Project Name / File No.: Soper Hill Station (Permit #: PA22-030)
Applicant: Soper Hill Station, LLC
Project Description: Administrative Review – Site Plan
Site Address: 8907 Soper Hill Rd, Marysville
Review: Applicant's Response to (1st) Review

This letter serves as the Applicant's formal response to the 1st review comments received from the City of Marysville on August 19, 2022 to our recent application materials submitted to the city on July 5, 2022. To ensure that each of the comments have been responded to, we have incorporated each of the City's comments along with the Applicant's response to each below. The responses below are to inform you that we have addressed each of the City's comments so the review of the application may continue.

DRAWING TITLE:
LANDSCAPE PLAN

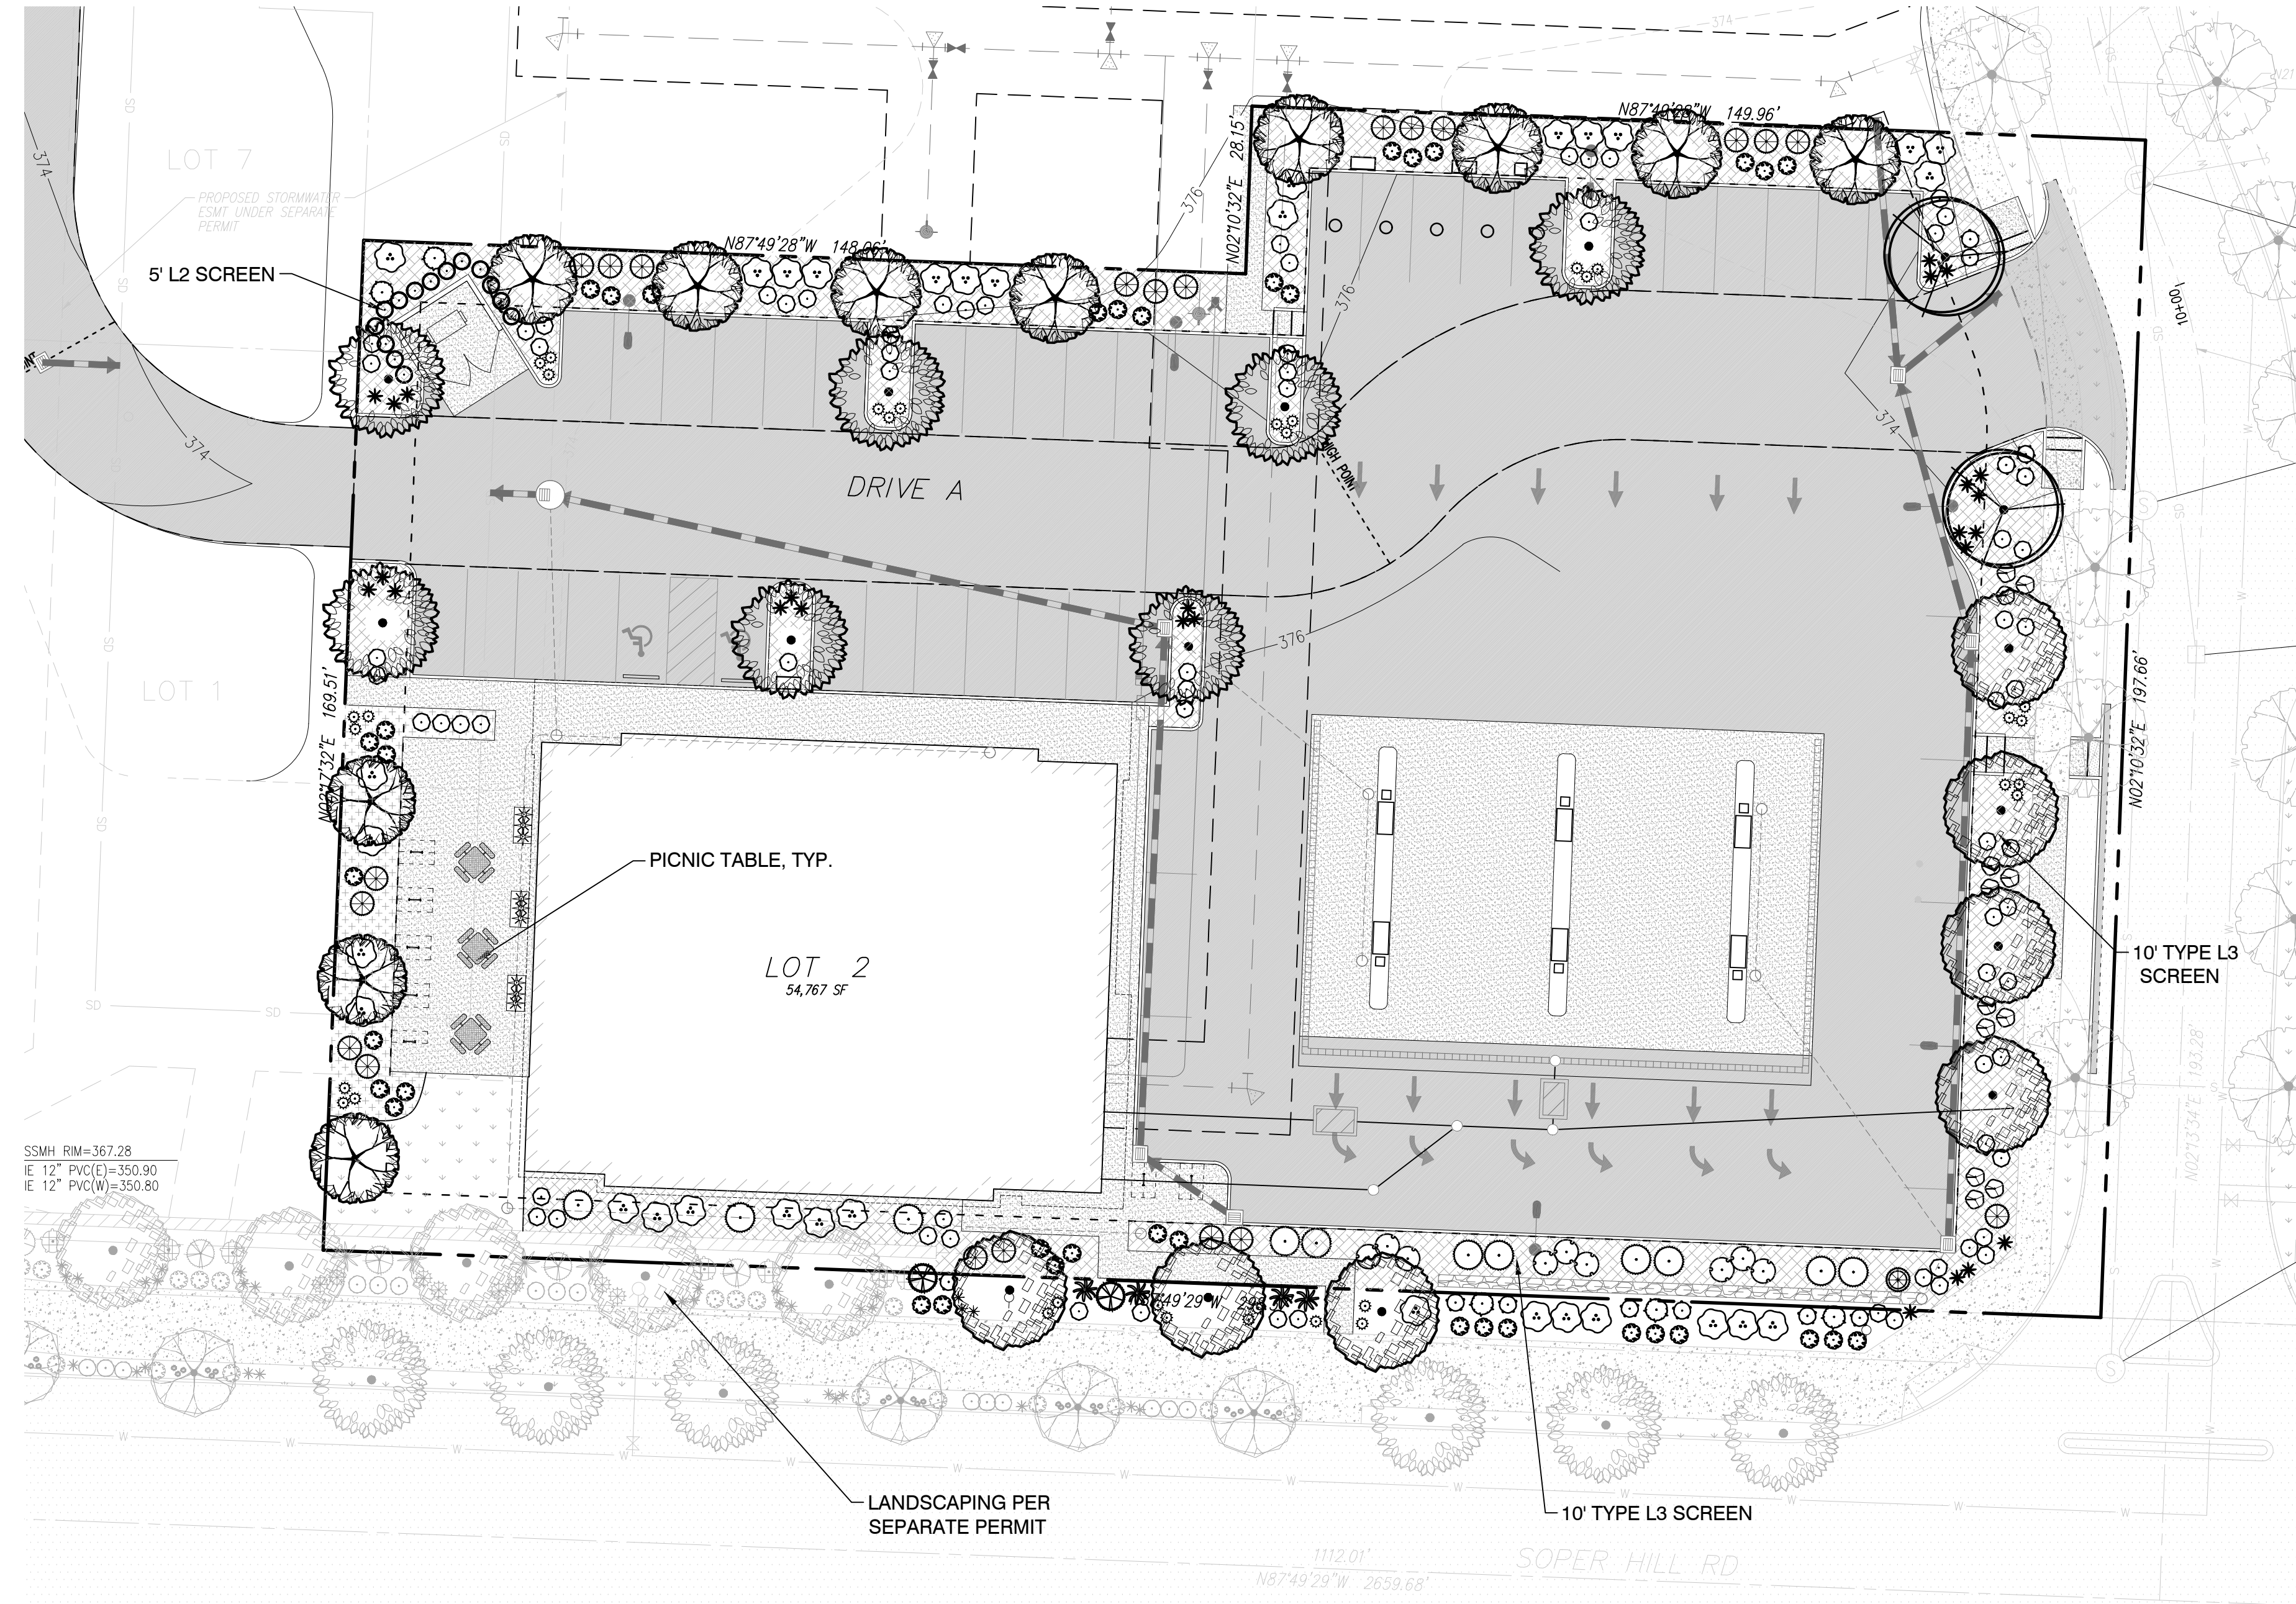
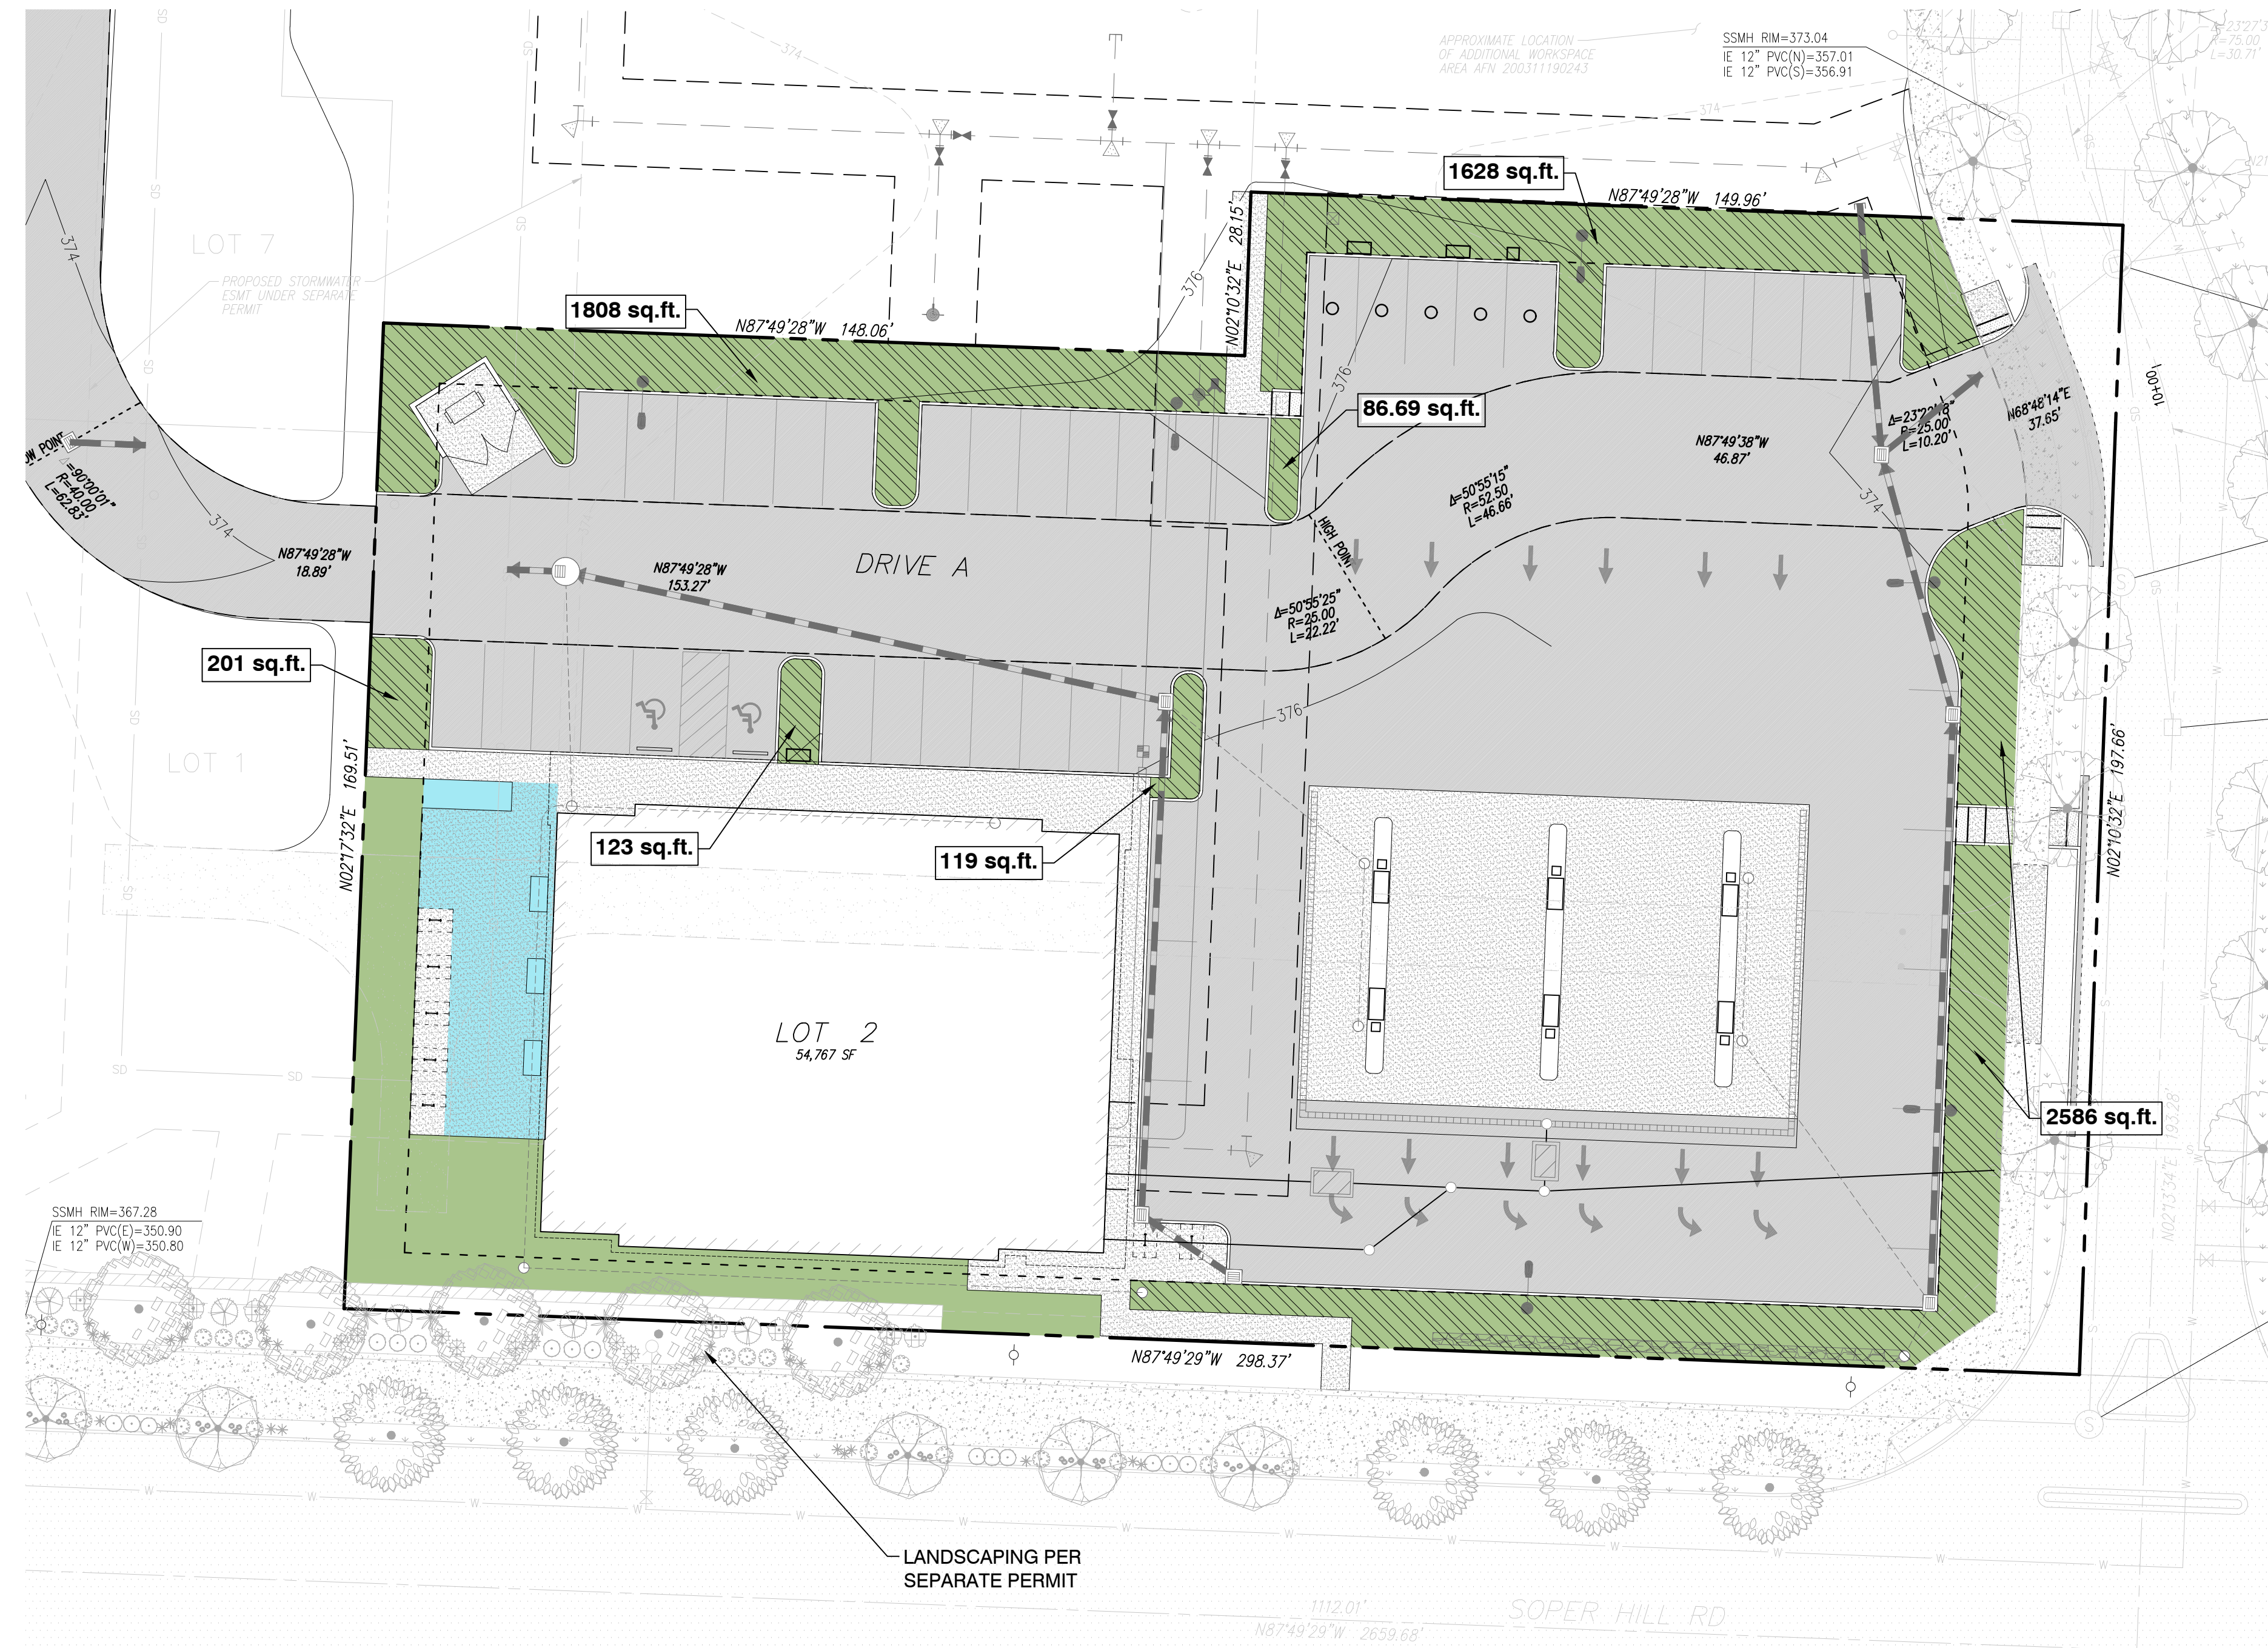
b. B.3.2.c. unscreened parking lots are prohibited adjacent to the open space. This could be accomplished by providing planting within pots on the north side of the open space.

c. F.1.1 requires a 30' landscaping setback from Soper Hill Road and a 20' setback is required from Road A when a parking areas and drive aisles are located adjacent to these roadways.

e. F.2.4.d.(1) requires the sides and rear of the solid waste enclosure to be screened with L1, L2, L3 or L4 landscaping at least 5' in depth.

f. A minimum 5' L4 landscape buffer is required at the end of the row of parking on the northeast portion of the parking area.

g. Recommend incorporating a variety of plantings with season colors within the 10' landscape buffer along the western property line adjacent to the open space, rather than lawn grass.

Applicant's Response: Landscape screening has been provided.

Applicant's Response: Per our previous conversation a Type L3 10-foot buffer has been provided along both Drive Aisle A and Soper Hill Rd. In addition, landscaping will be provided in the 5-foot planter strips between Soper Hill Rd and Drive Aisle A.

Applicant's Response: This has been updated and provided.

Applicant's Response: This has been updated and provided.

Applicant's Response: Provide and land area reduced.
